LAW OFFICES OF RICHARD T. COLE, P.S.

April 21, 2021

RE: SE-21-00006 Nunnally

DRAWING NO.	C1.1
PROJECT NO.	20.010
DATE:	11/23/20
SHEET NO.	2 OF 10

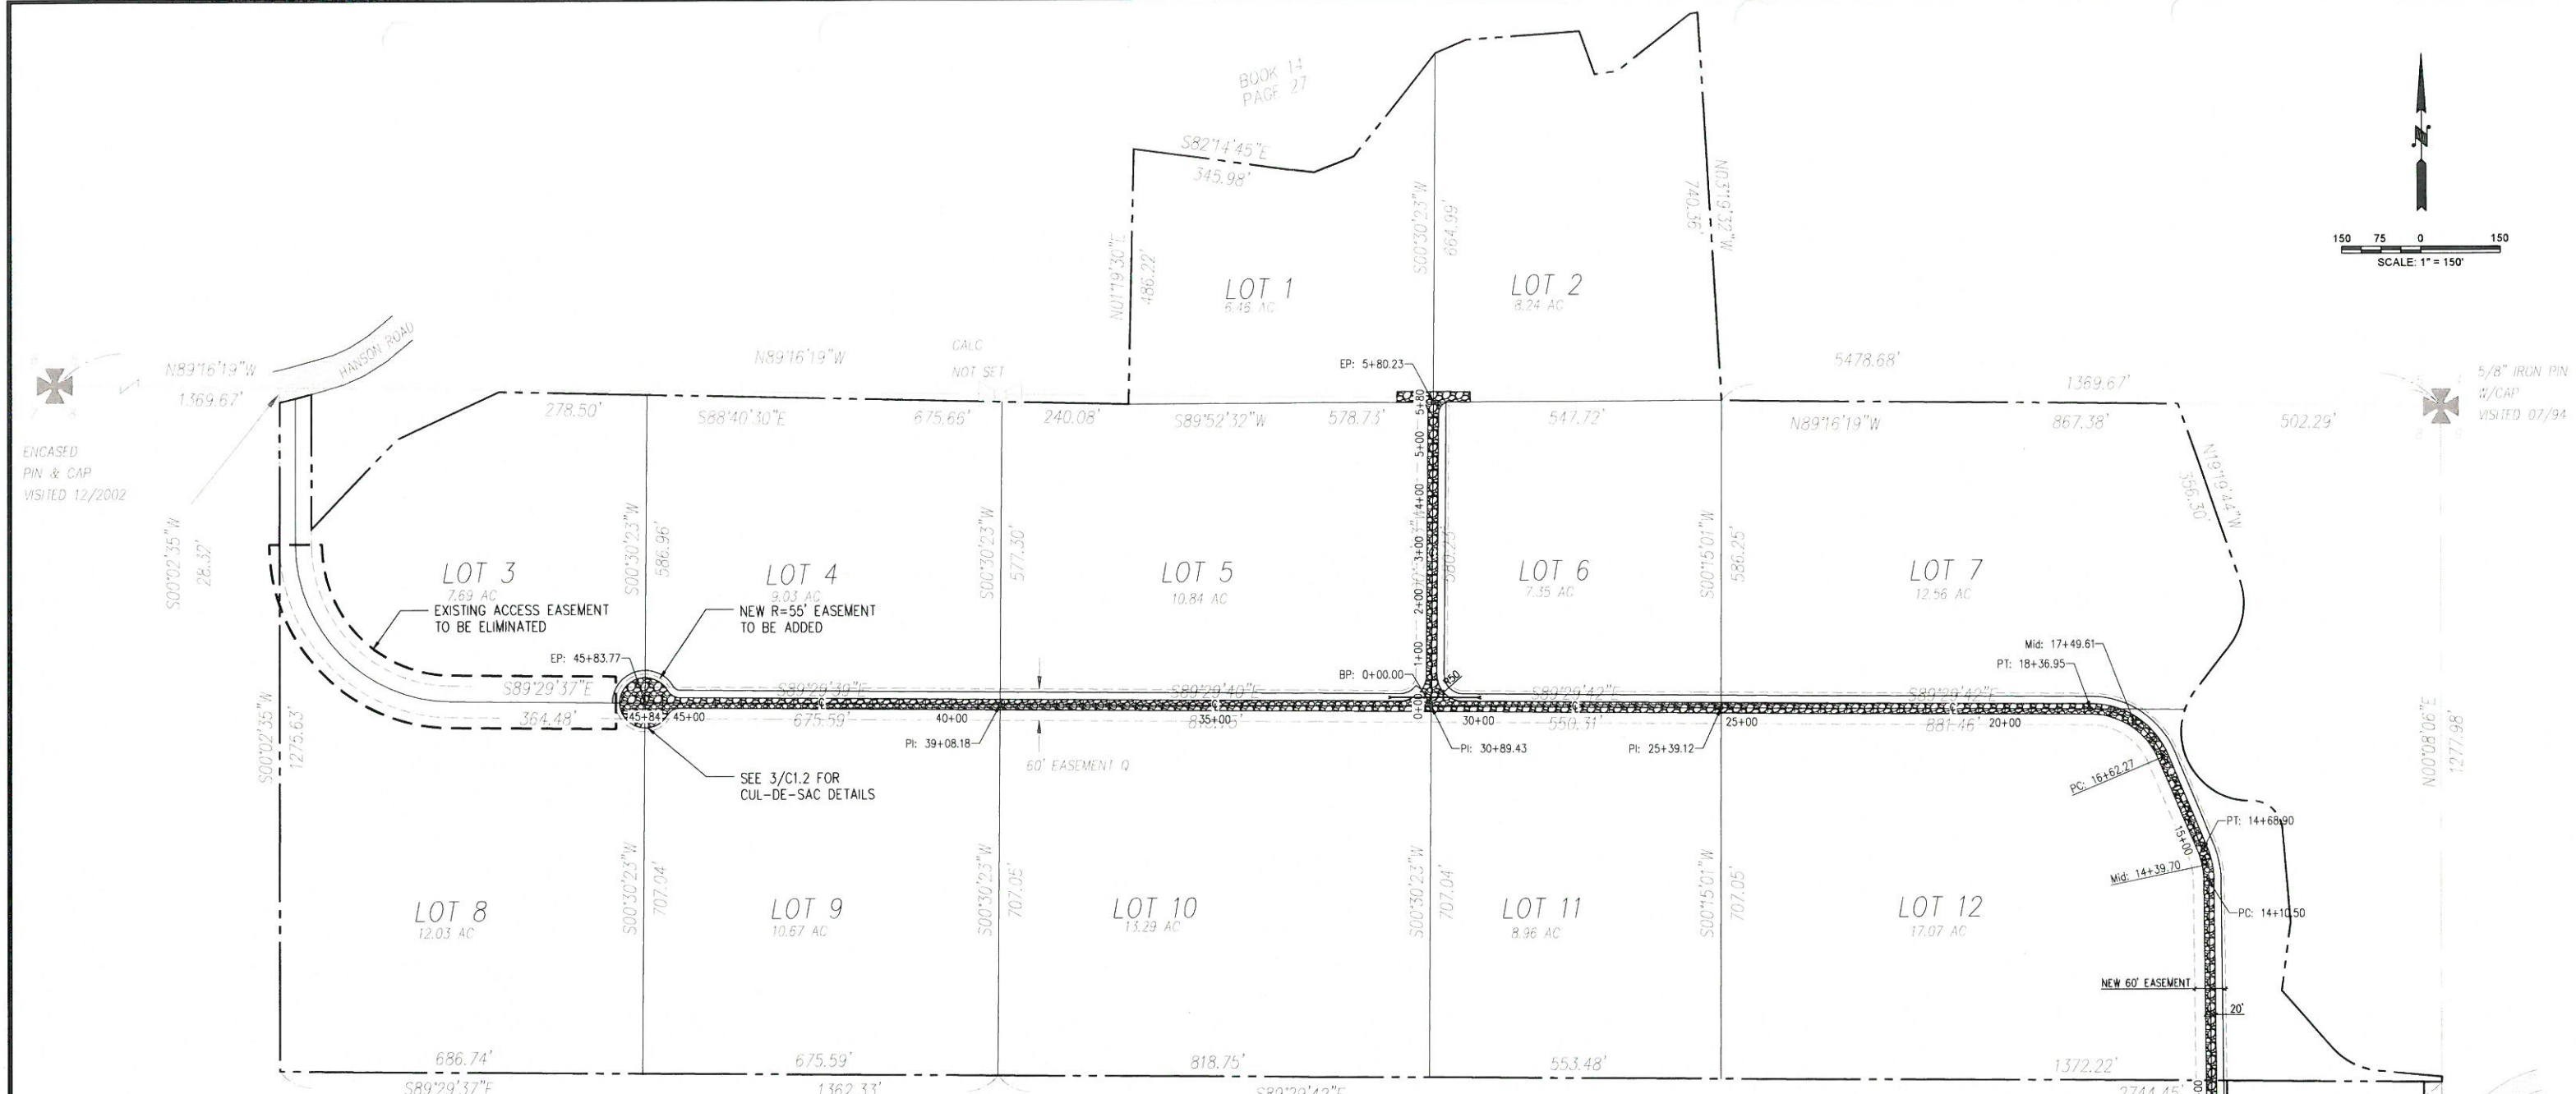
8. The Browns will be adjacent to lots 1, 3, 4, and 5, as the lots are now configured by the site plan submitted. Portions of these lots were all subject to most recent flooding of Manastash Creek.

9. The Development Services should make sure that the Kittitas County Reclamation District distribution plan for this acreage is properly acknowledged and followed pursuant to KRD's instructions, and that individual landowners are made aware of their responsibility to keep this irrigation water contained within the boundaries of their own properties, and not to flood adjoining acreages. In the past Lot 1 has flooded the Brown's basement to a level of 3 feet until conversion to sprinkler methods; if the new owners of Lot 1 go back to flood irrigation methods, a problem could result.
